From: David Uncles [REDACTED]
Sent: 20 November 2020 22:43
To: Andrew Wood <Andrew.Wood@arun.gov.uk>
Subject: Application_Ref_No=EP/124/20/HH

OBJECTION

I have studied the proposed development incorporated in Application reference EP/124/20/HH submitted in conjunction with a supposedly reputable local architect. This is very disappointing. The result to me is of a proposal that is audacious and reckless in equal measure.

Location Plan and Block Plan

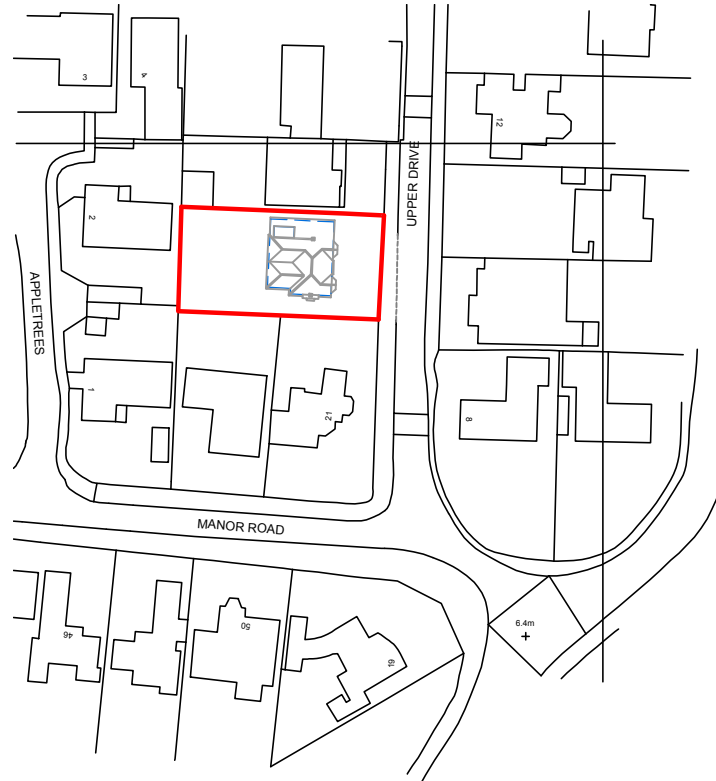
- * By way of offering a more viable alternative, it would appear the property benefits from a generously sized rear garden. According to the applicant's architect's own drawings there is a gap of almost 12 feet between the property and its Southern boundary. This gives ample vehicular access to the rear of the property where the construction of a garage with the dimensions proposed might be considered more favourably both by local residents and the planning authorities.

Garage Plans and Elevations -
Proposed

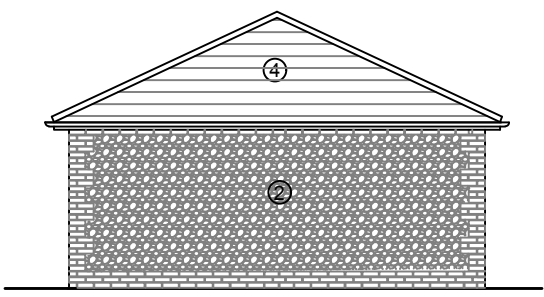
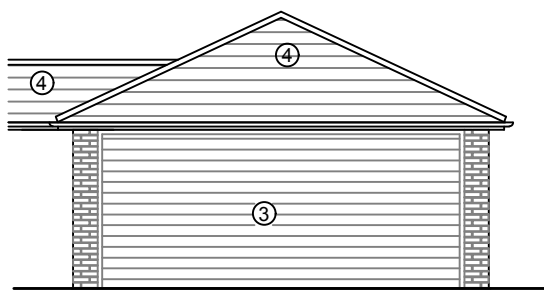
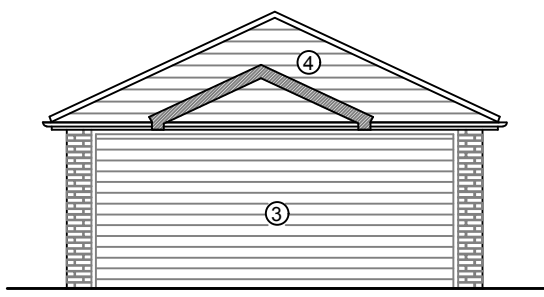
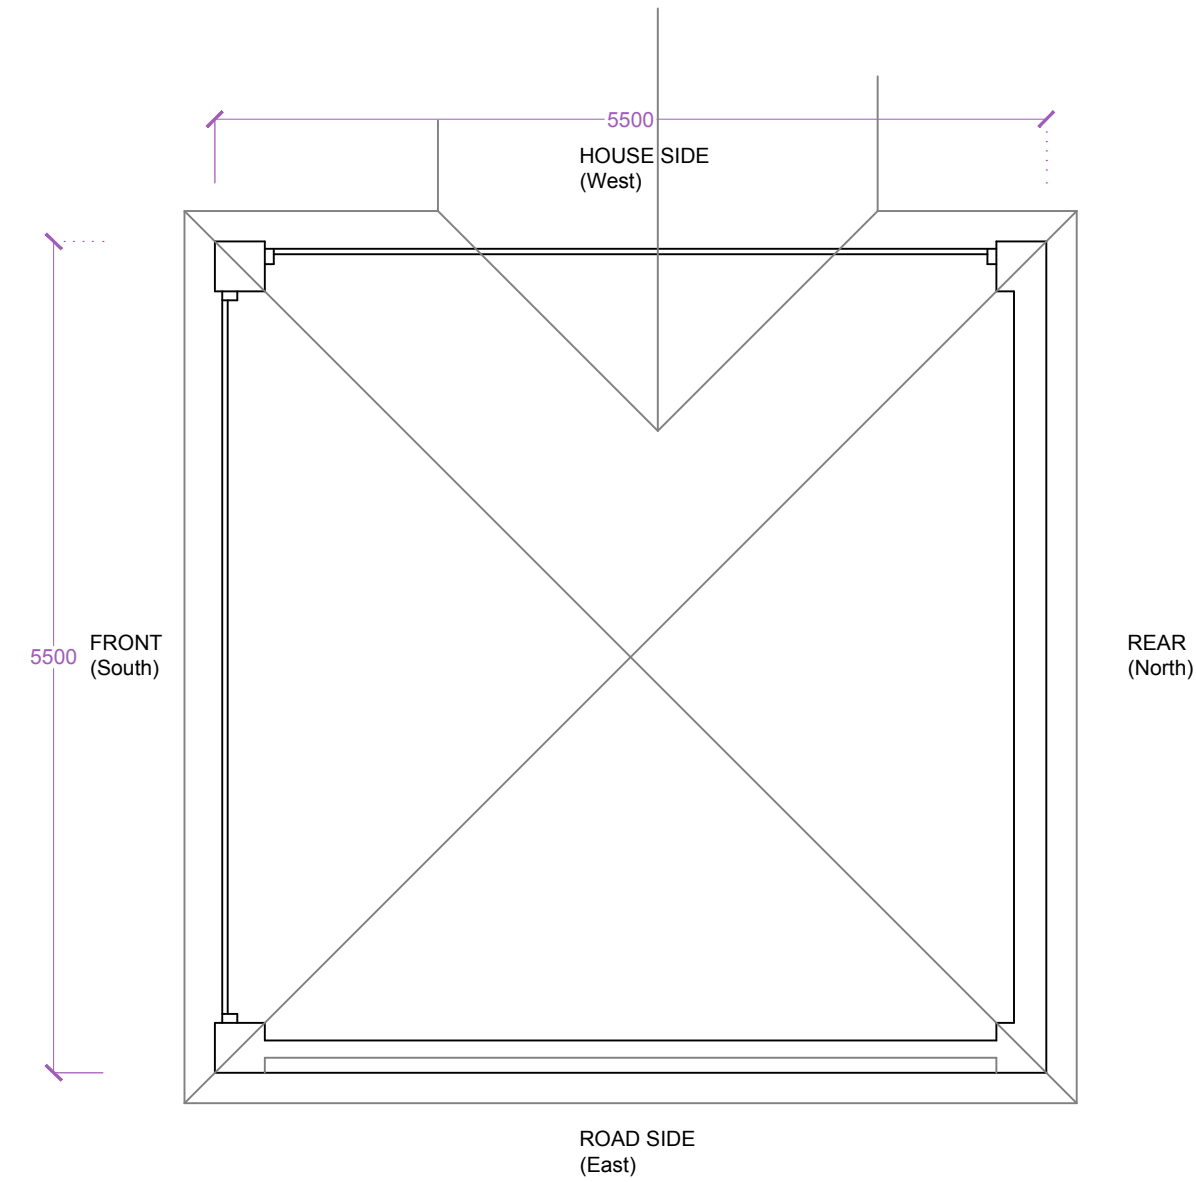
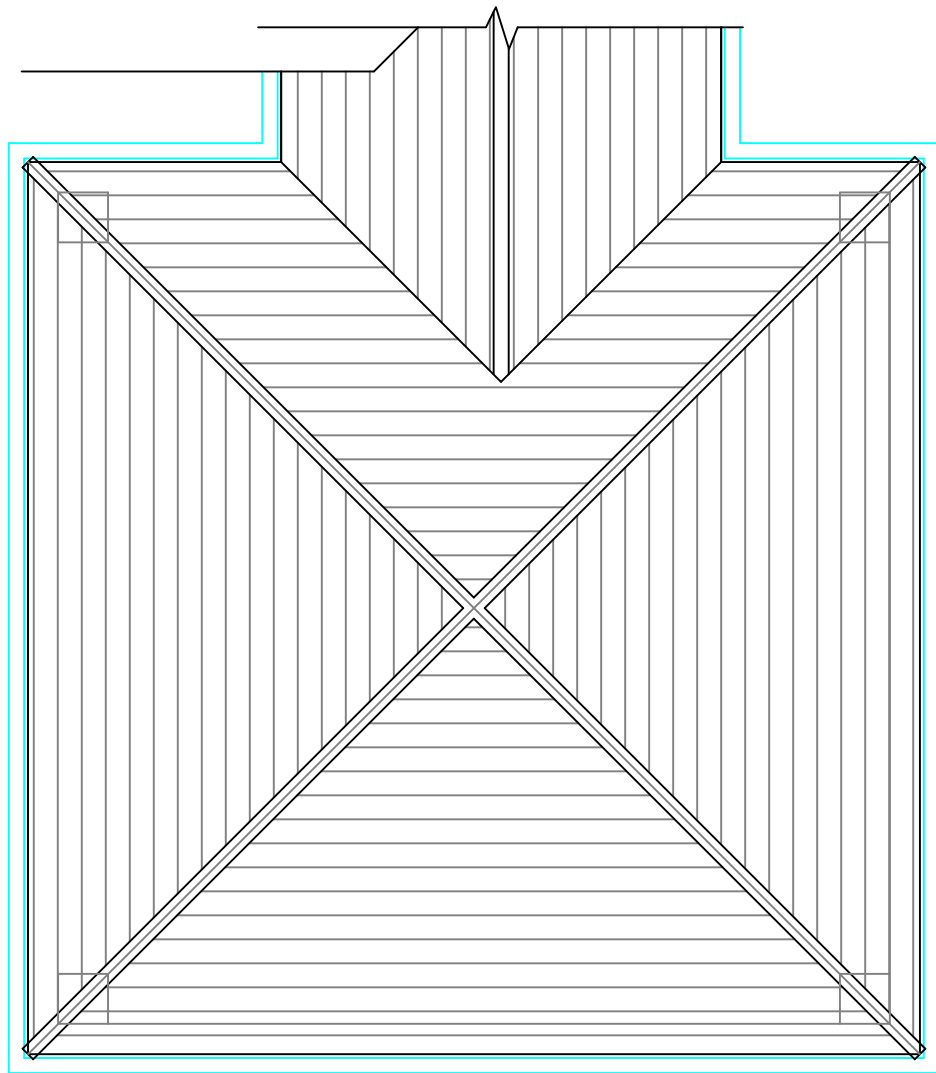
- The proposal unquestionably adversely affects the amenity of the householders immediately to the North of the development.

- The existing building line has been totally disregarded.

- The proposed structure virtually abuts the Northern and Eastern boundaries of the applicant's property. In this position a garage of the dimensions proposed would be disproportionate and both out of place and out of keeping with every other property in Upper Drive.
